WELWYN HATFIELD COUNCIL – DEVELOPMENT CONTROL
DELEGATED REPORT

APPLICATION No:	S6/2007/1466/FP
------------------------	------------------------

RECOMMENDATION: REFUSAL AND REASONS

project	PLOUGH HILL AND HILL RISE CUFFLEY	drawn	audited	scale	date
		DWC		1 - 100 AT A3	09 - 07
drg title	HOUSE TYPE 180 PLANS AND FRONT ELEVATION	job no.	06 04	drg.no.	rev
				P 04

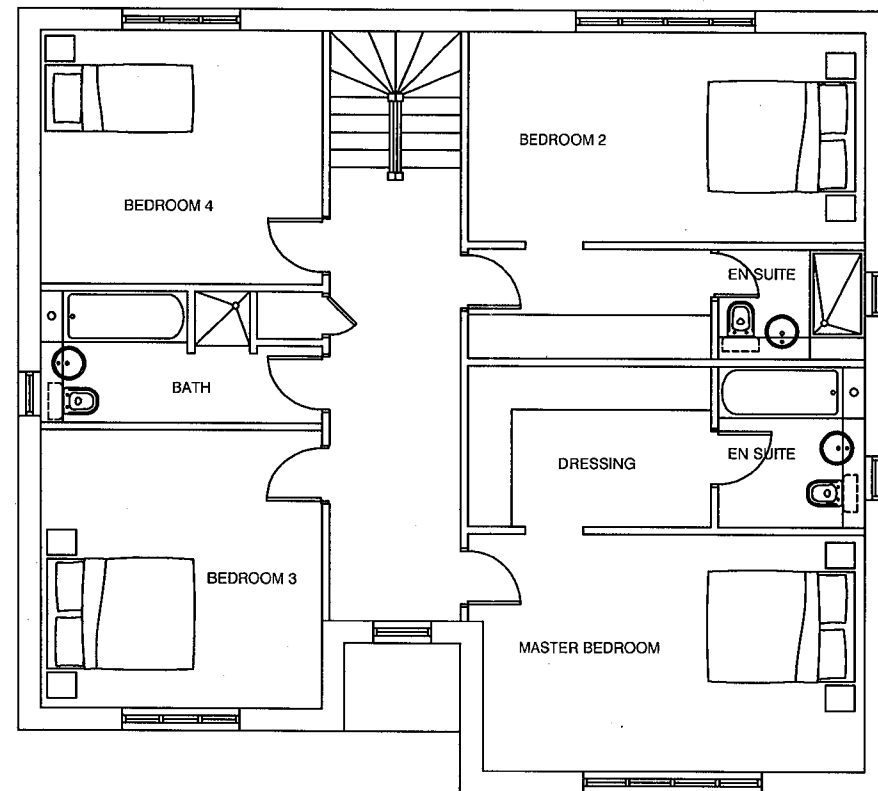
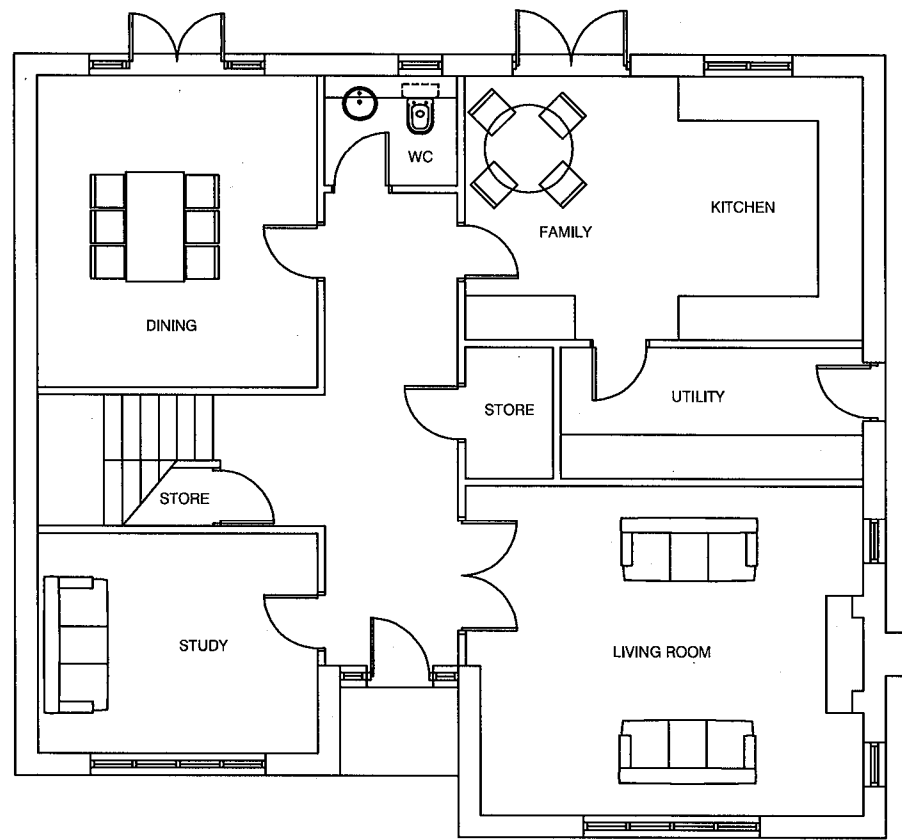
Plot 2 would accommodate a house measuring a maximum of 11.5m in width by 10.4m in depth with a hipped roof to a maximum height of 9.4m.

The proposed dwellings have been illustrated to be two-storey, but the properties on plots 1,2 and 4 would be capable of accommodating a further floor within the roof space without substantial alteration. The proposed dwellings would be very different from the properties on Hill Rise and Plough Hill. The existing properties on Hill Rise and Plough Hill have shallower roof heights and although some of these properties are large, they appear in proportion. The proposed dwellings have also failed to reflect the character of the properties on Kingsmead and to the north east of the site. These as dwellings are generally single storey and 1.5 storey in appearance with low eaves heights and have a more modest appearance.

project	54, 56 & 58 PLOUGH HILL AND No 2 HILL RISE, CUFFLEY	drawn	DWC	checked	—	scale	1 - 100 AT A1	date	09 07
site	PLOTS 3 AND 4, ELEVATIONS.	job no.	07 04	drawn no.	—	sheet no.	P 03	rev	—

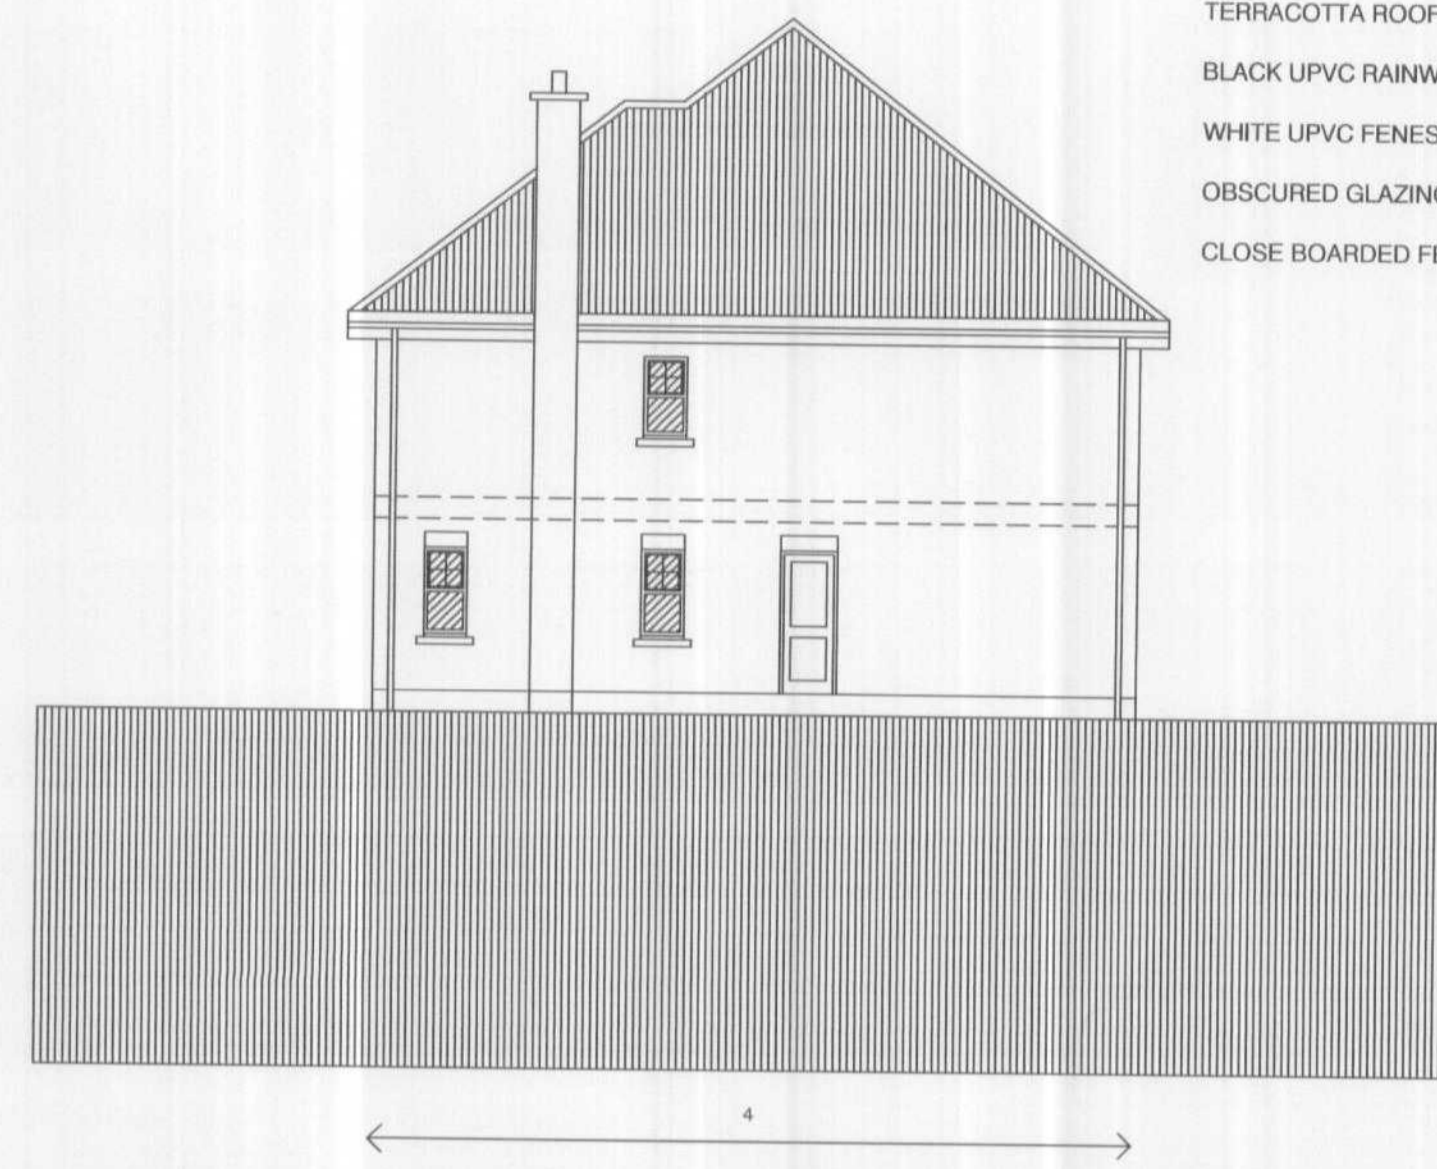
The agent has failed to provide plans illustrating all of the elevations to the proposed dwelling on plot 3. The Design and Access statement contains several inaccuracies and appears to partly be for the previous application under reference S6/2007/852/FP.
